Preliminary Acceptance Punchlist
El Paso County – Department of Public Works - Stormwater Section

Project Name:	Sterling Ranch F3
EDARP Filing Number(s):	SF2132, CON2238
ESQCP Number:	ESQ2217
Attendees:	DPW SW: Dylan Finley, Glenn Reese DPW Development Services: Brad Walters, Spencer Pirzadeh, Joe Jackman Developer: Chaz Collins, Peter Morley, Jim Morley
Date of Walk-through:	08-13-2024
Walk-through Number:	1 st

SHEET 2 OF 7

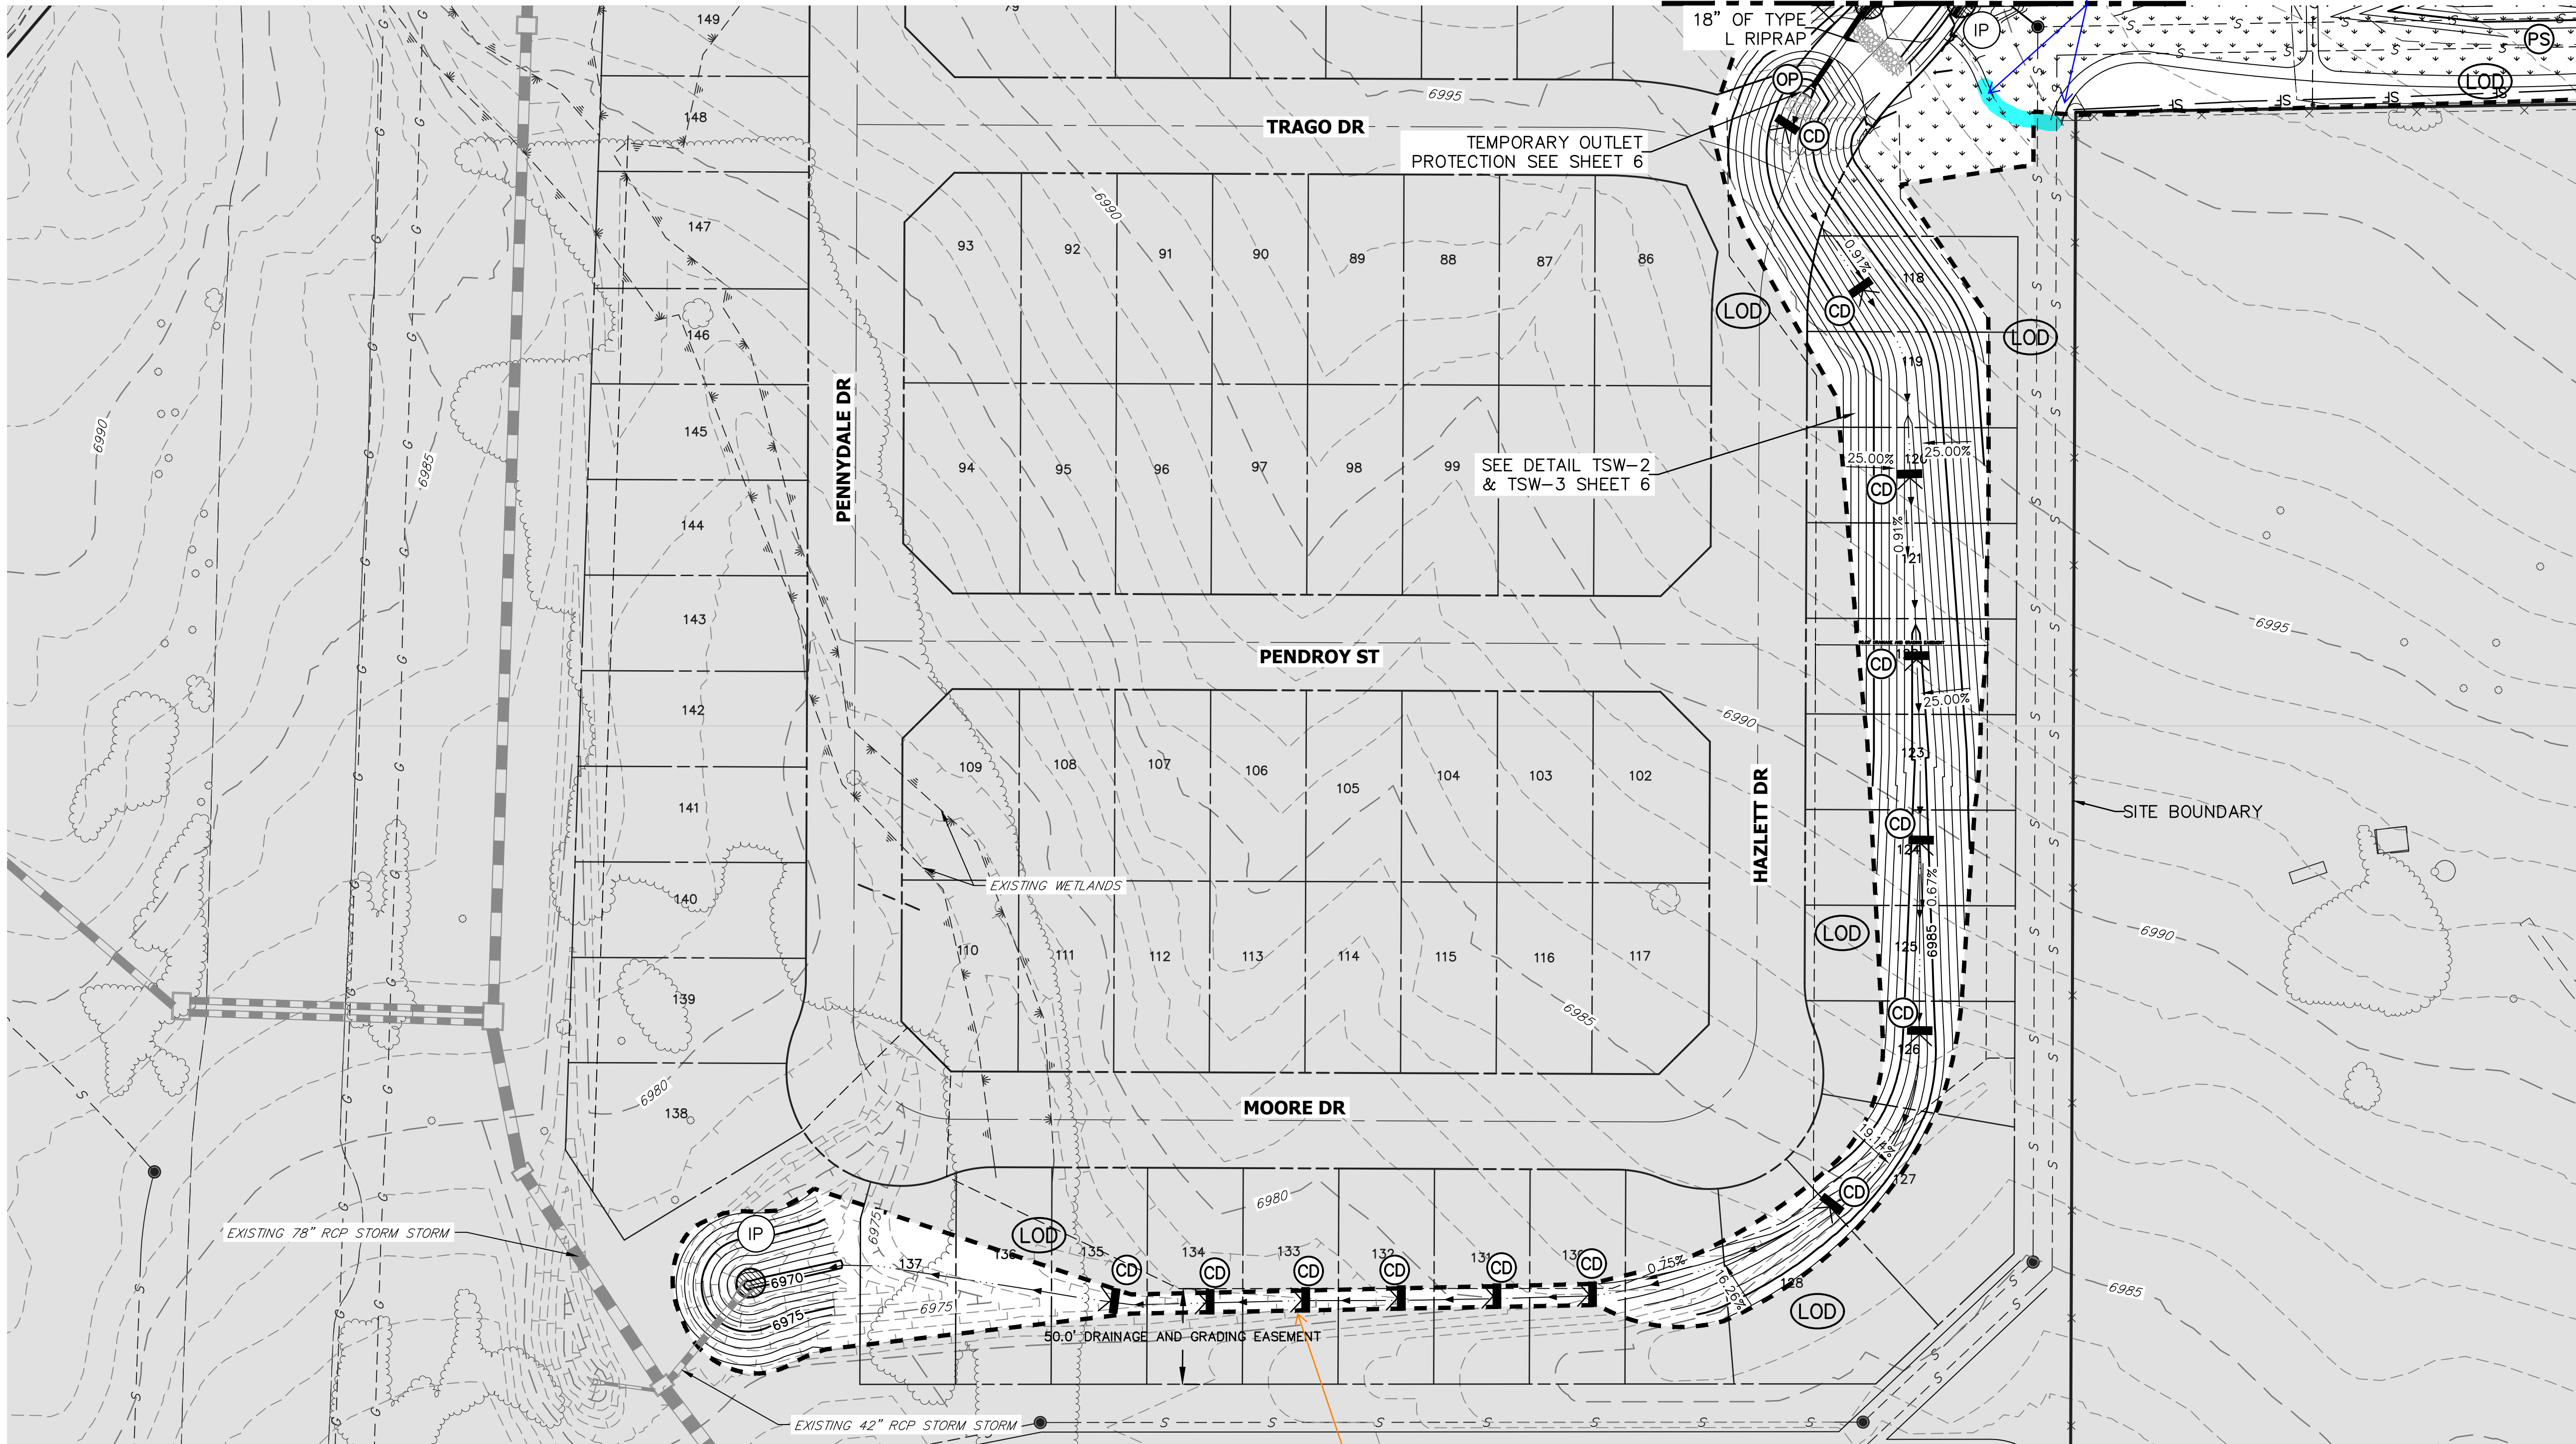
- Swale to the area drains in Tract C not installed per plan detail. The area drains are mostly above grade such that no runoff is tributary to them. Install per approved plans and stabilize. Reference Sheet 2 of 7 of GEC Plan.
- Regrade and stabilize Tract A and open spaces.
- Swale behind lots 6-8 not installed per plan detail. It was installed much wider than what is shown on the plans. Install per approved plans or confirm with your project engineer that this change from the plans is acceptable and then reflect the change on the as-builts. Reference Sheet 2 of 7 of GEC Plan.

Photo 1: Swale behind lots 6-8 not installed per plan detail. Install per approved plans or confirm with your project engineer that this change from the plans is acceptable and then reflect the change on the as-builts. Reference Sheet 2 of 7 of GEC Plan.

Photo 2: Swale to area drains in Tract C not installed per plan detail. Install per approved plans. Reference Sheet 2 of 7 of GEC Plan.
